RE: Permit # 2309-048

Responses Intake Screening Incompletion (dated September 14, 2023)

Permit # 2309-048 – Response to Screening Incompletion

SHEET NUMBER:
C0.1

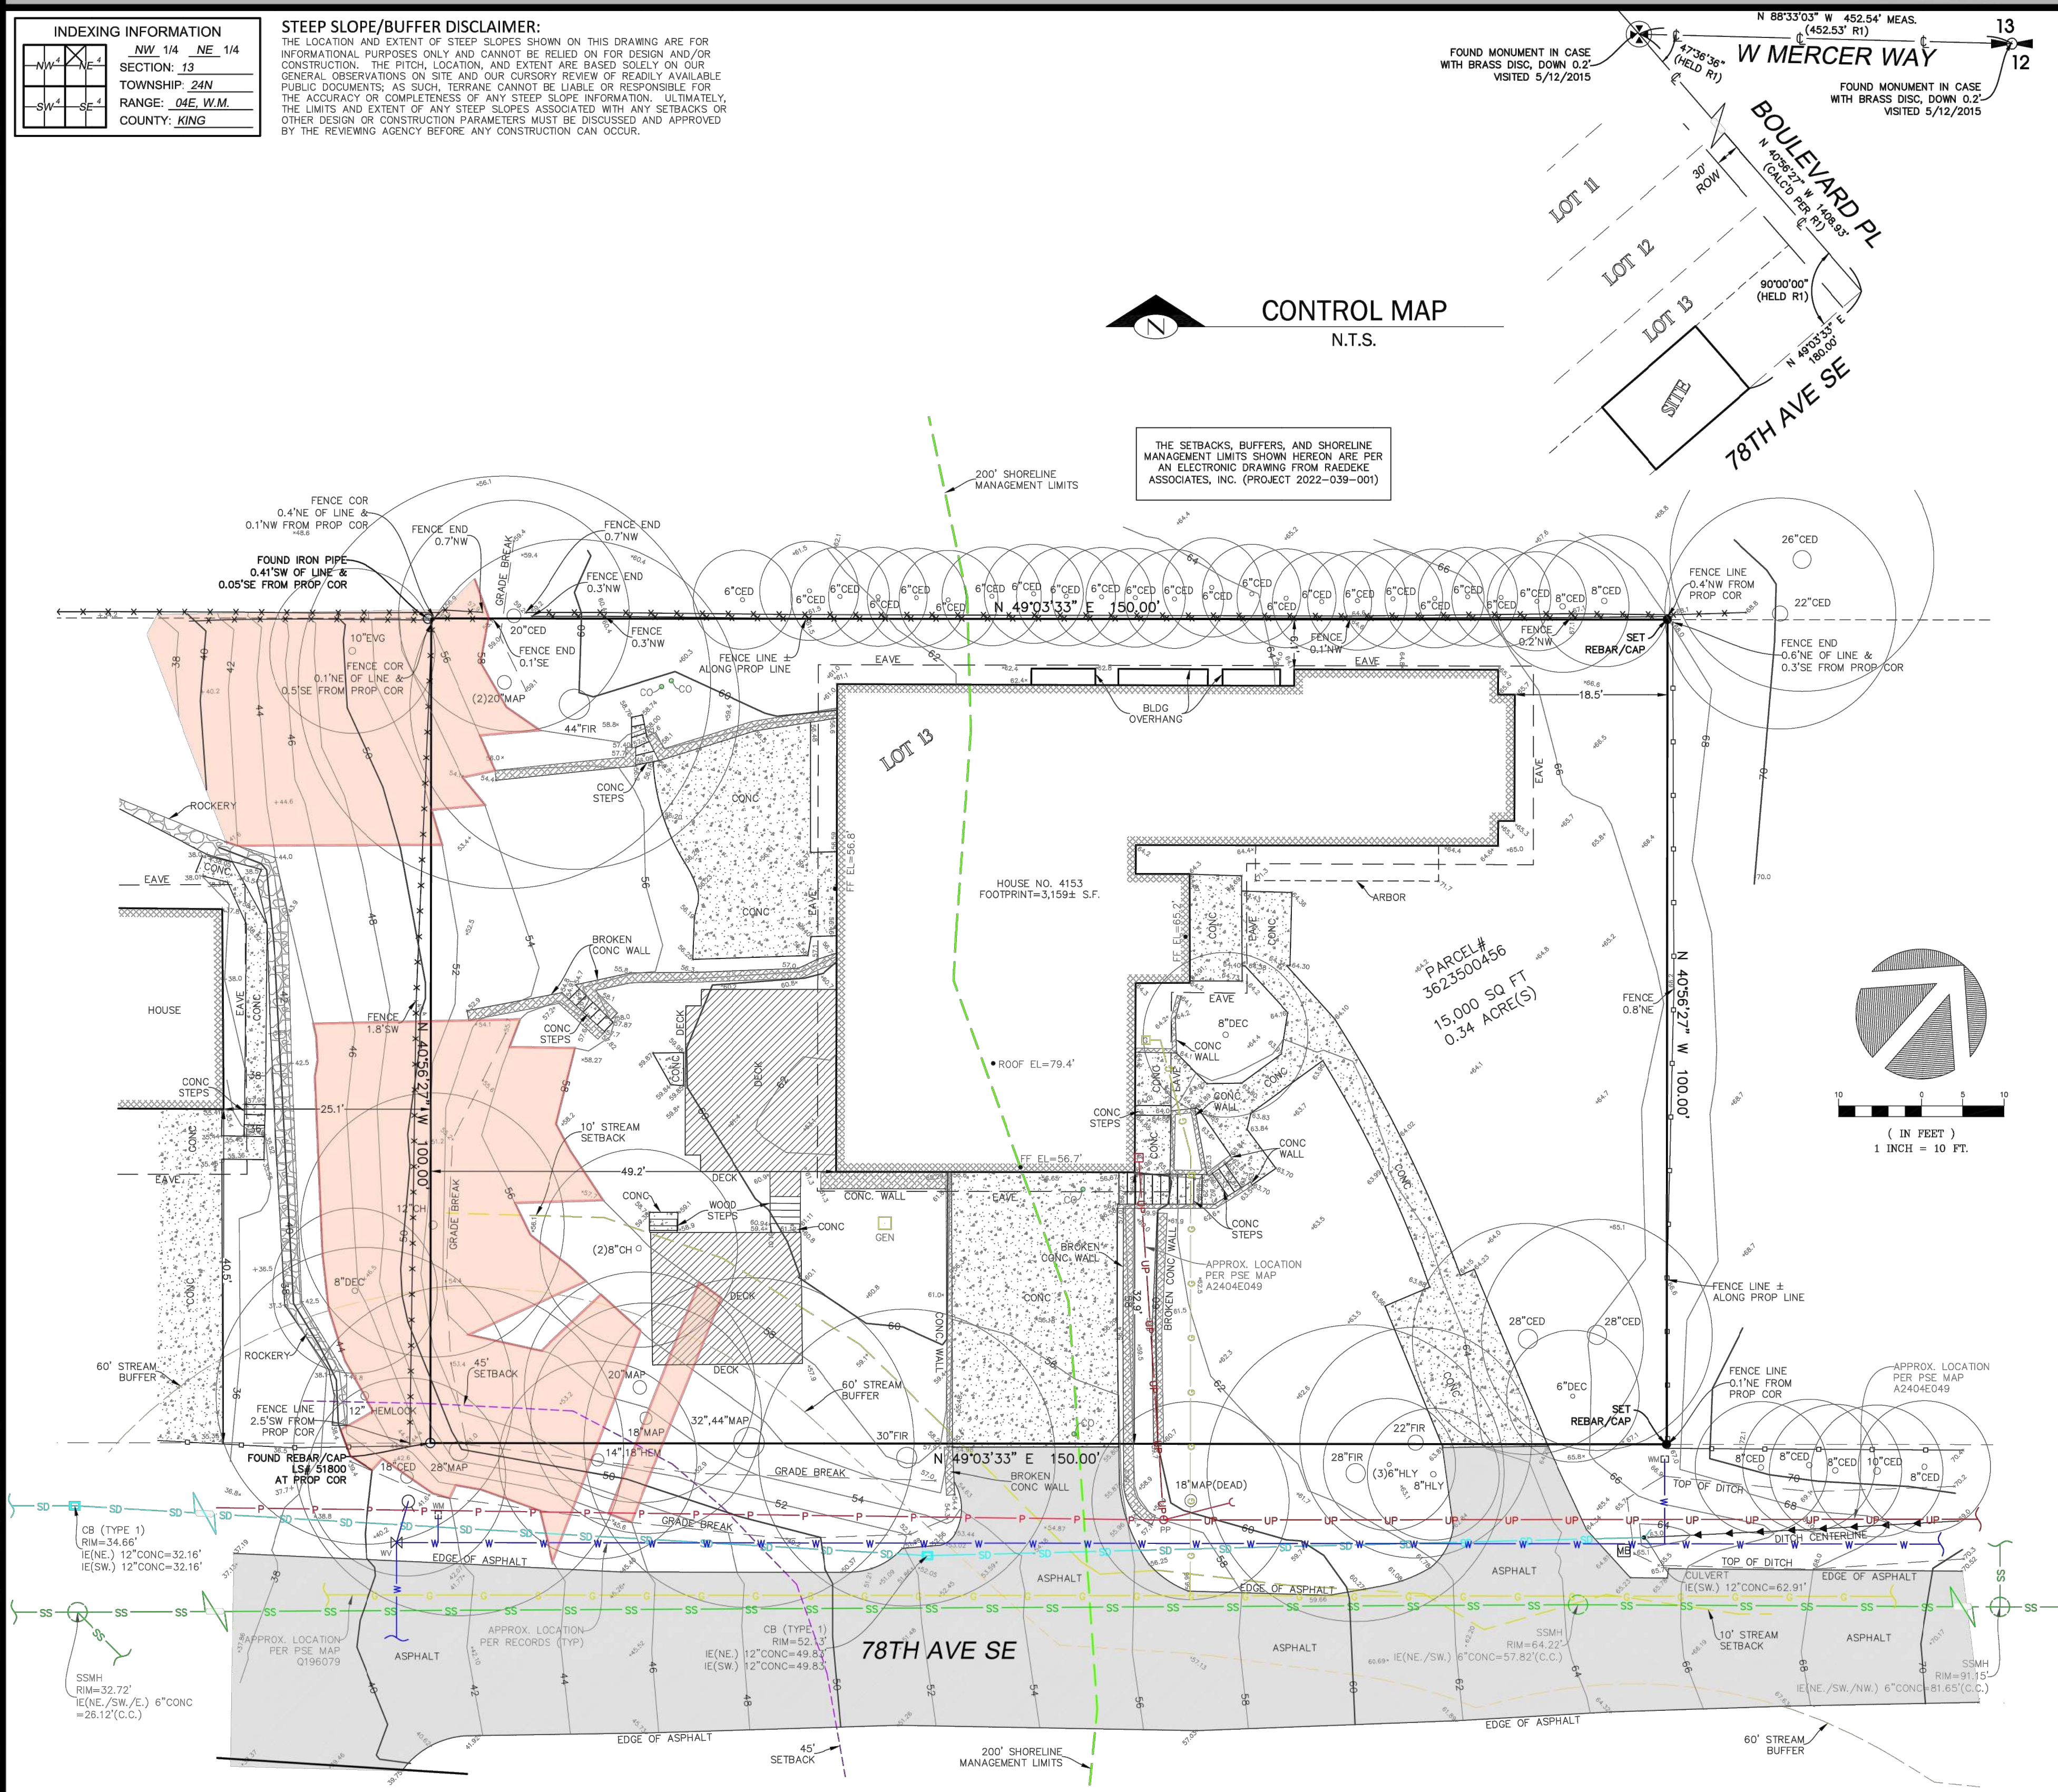
1. Indicate critical areas and buffers (wetland, watercourse, steep slope)

6. Indicate watercourse buffer located on this property.

Response: *Critical areas have been indicated on sheet A0.2. Steep slope area has been indicated on Sheet C0.1 and A0.2. Buffers have been indicated on sheet C0.1 and A0.2, including 200’ shoreline management limits, 60’ stream buffer, 10’ buffer setback, and 45’ piped stream setback.*

Response: *Watercourse buffer locations have been illustrated on sheet C0.1 and A0.2.*

COMPLIANCE CALCULATION FOR MICC 19.01.050(D)(1)(b)(i)

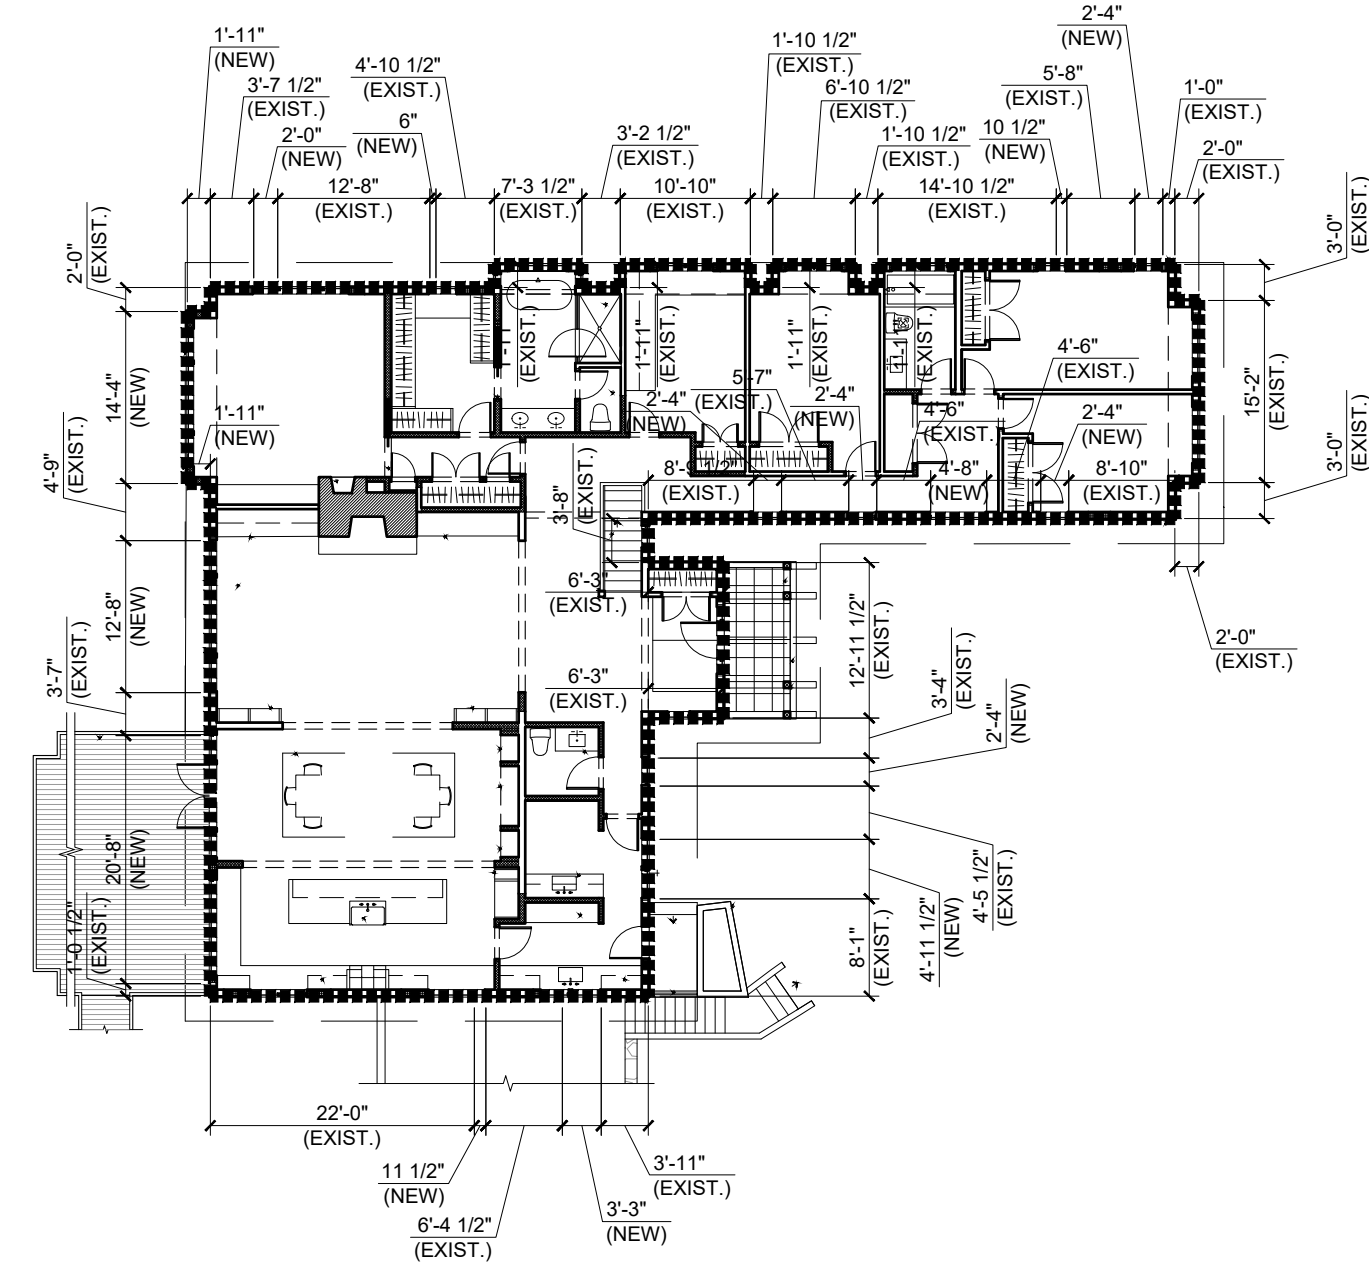
3. The home is protruding into the required yard setbacks making this a legally nonconforming structure. Add calculations to show no more than 40 percent of the length of the dwelling’s existing exterior walls, excluding attached accessory buildings, is structurally altered. Any portion of the length of existing walls that is structurally altered shall be included in calculating the 40 percent threshold (MICC 19.01.050 (D)(1)(b)(i)).

Response: *See sheet A0.2 for diagram and calculation indicating compliance.*

DIAGRAM - CRITICAL AREA - SEISMIC

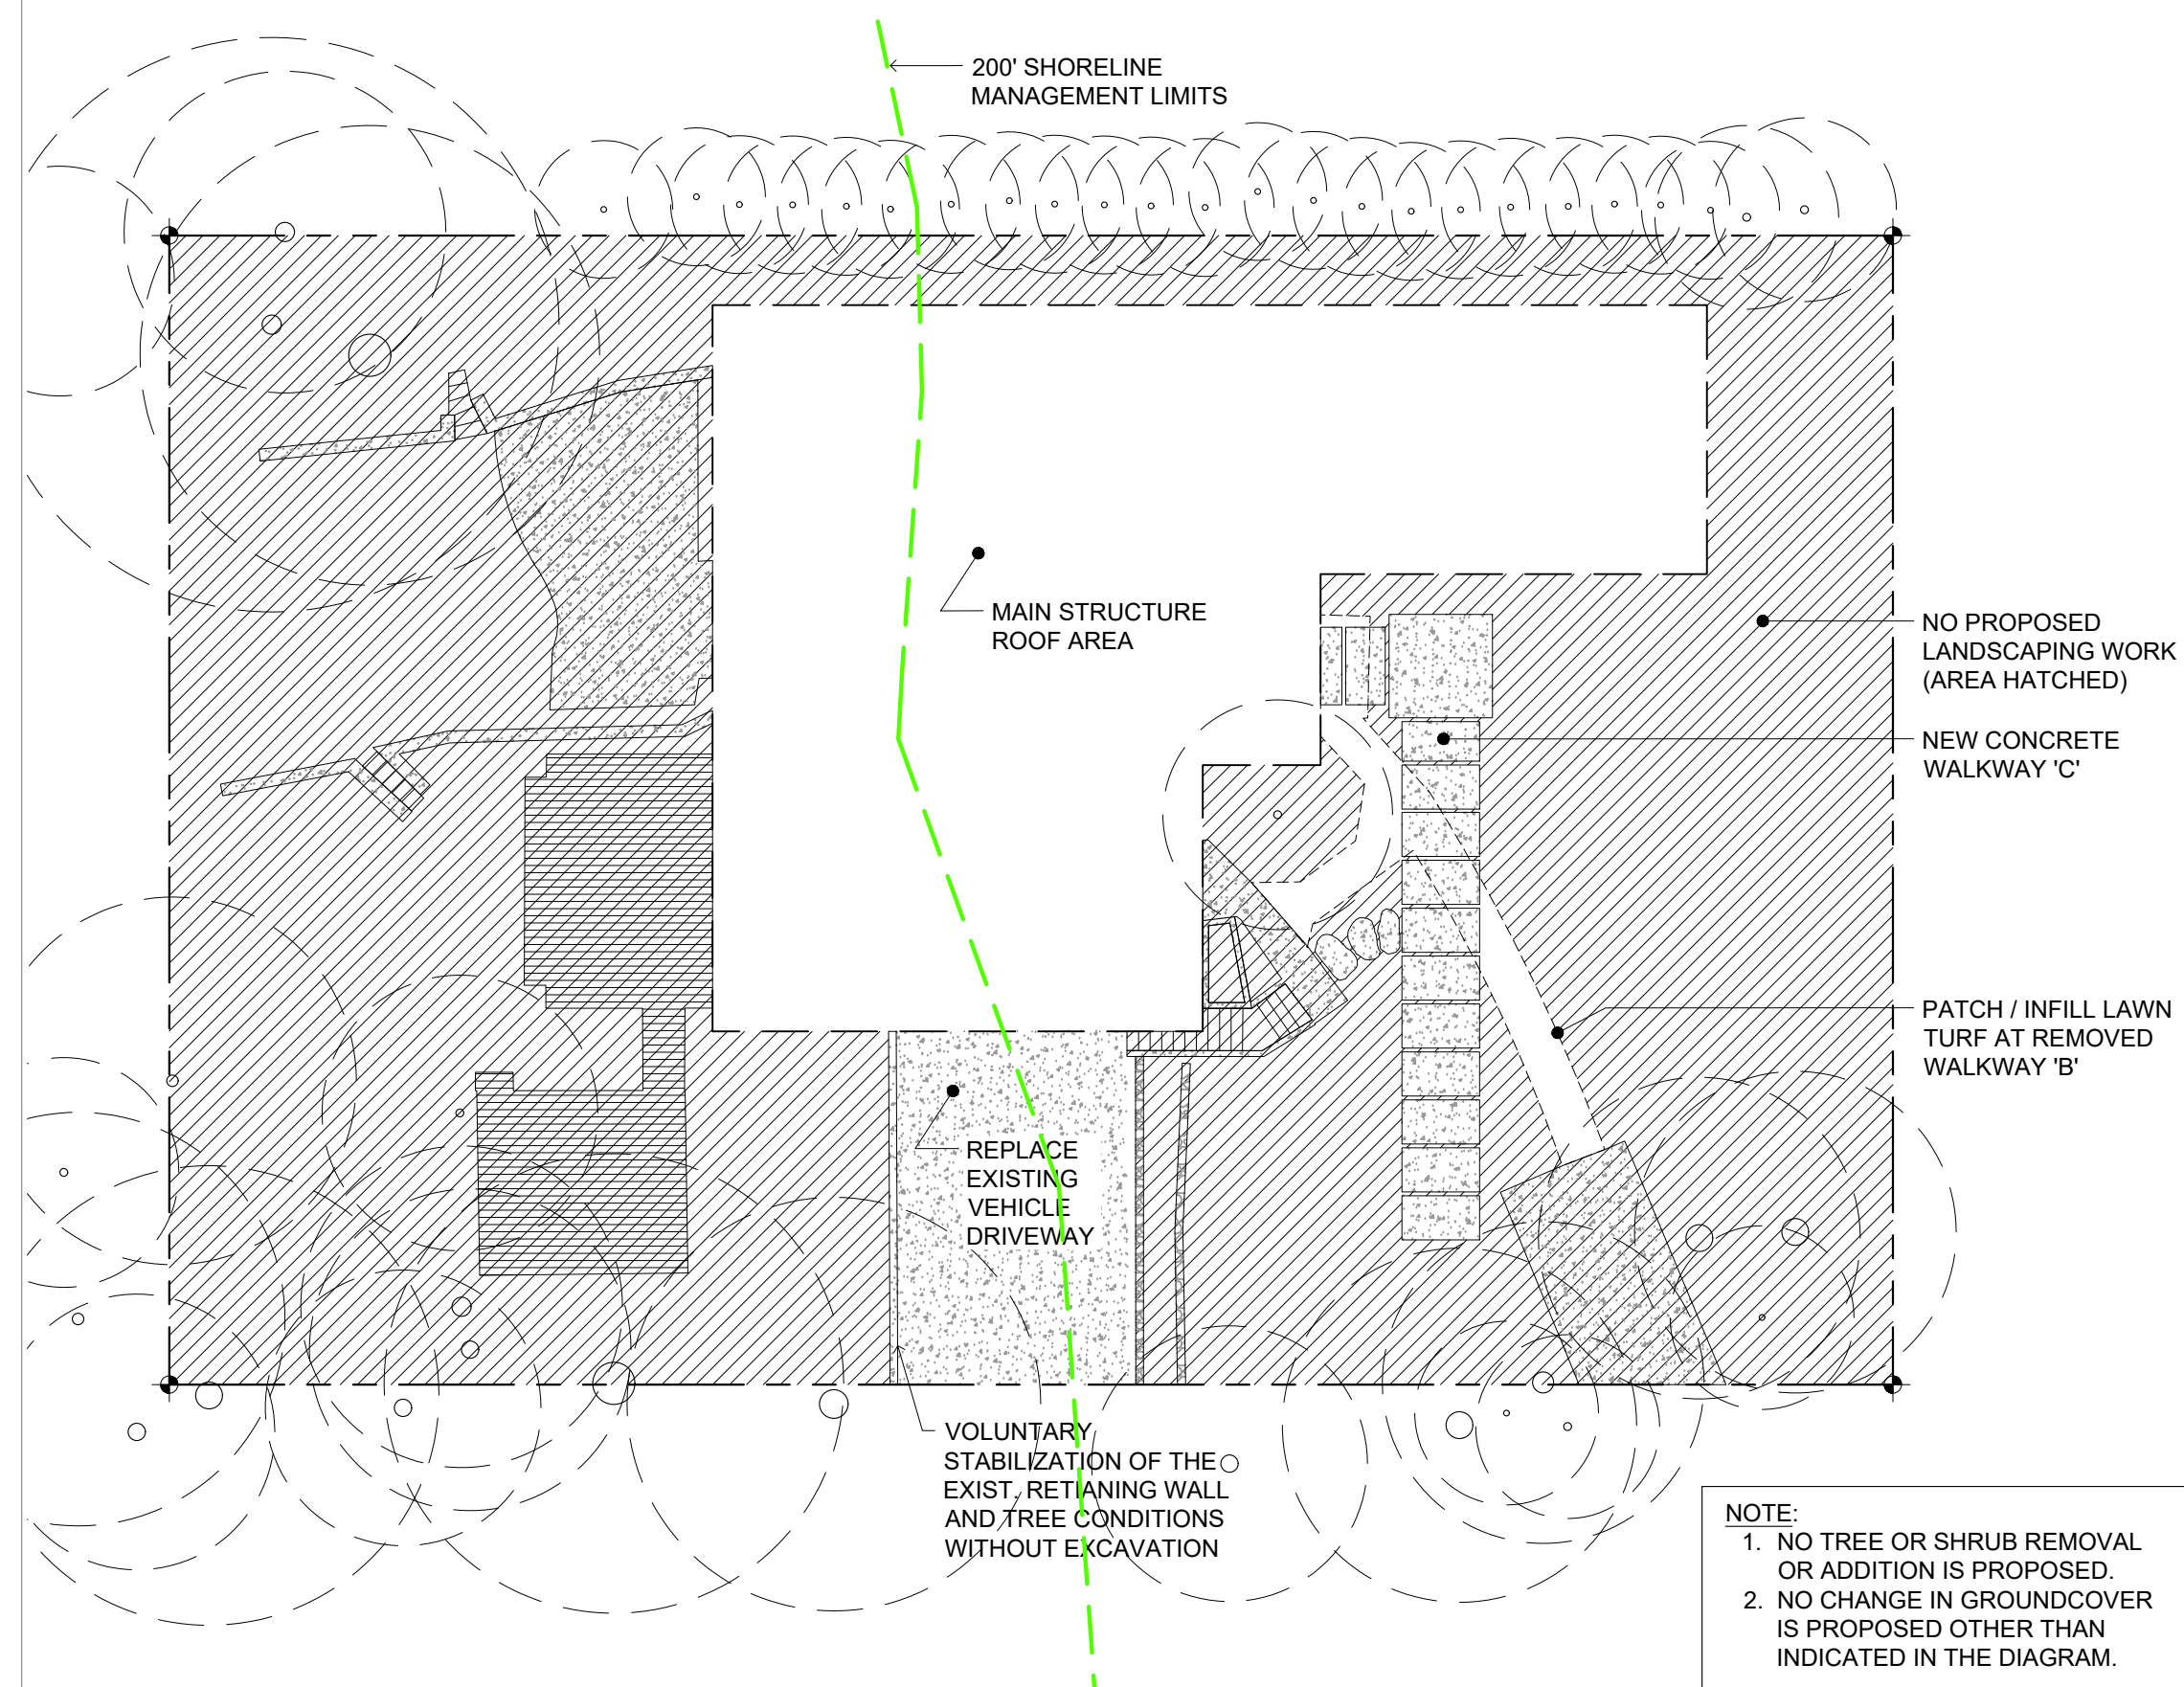
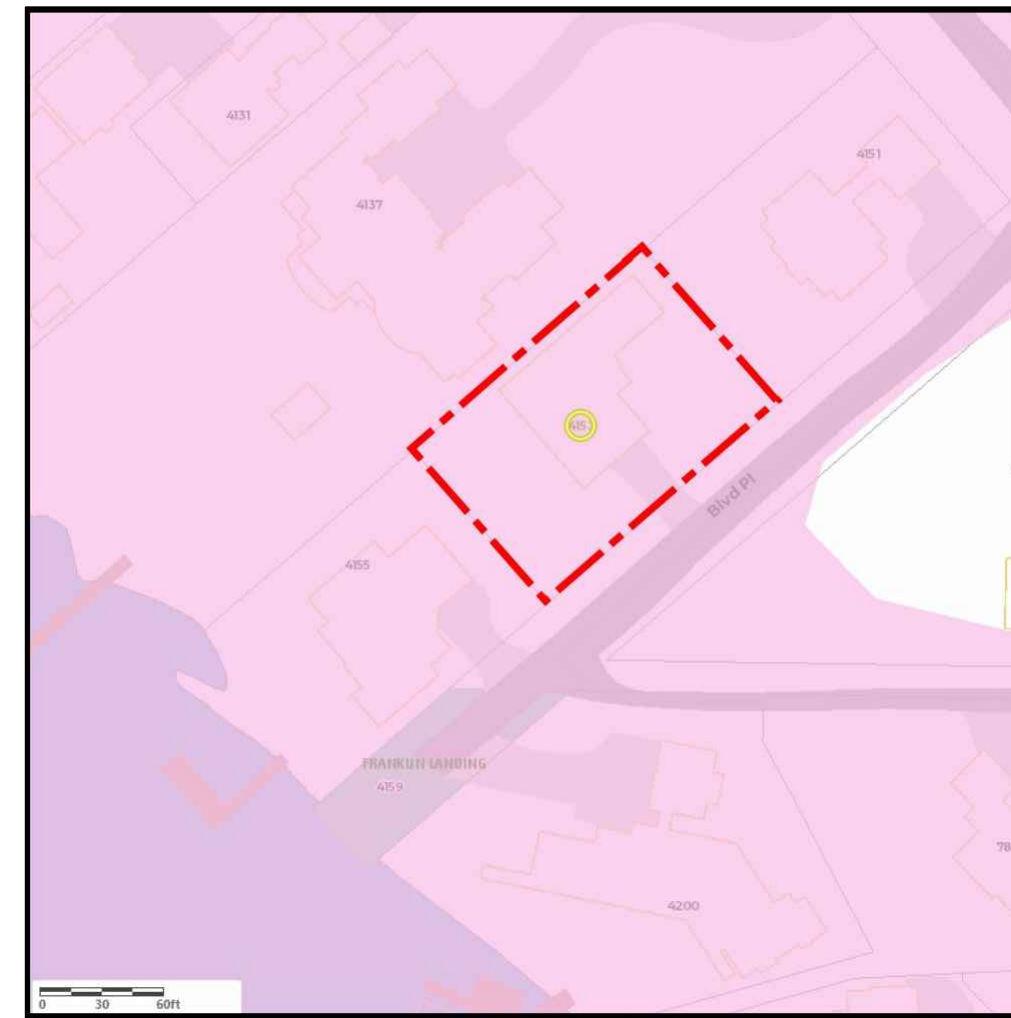
5. Show how the proposed work meets the criteria in MICC 19.07.130. If it cannot be shown that the project meets the criteria in the above code section then a separate critical area review 2 application is required per MICC 19.07.090(B)(2)(c).

Response: *See sheet A0.2 for notes indicating compliance with MICC 19.07.130.*
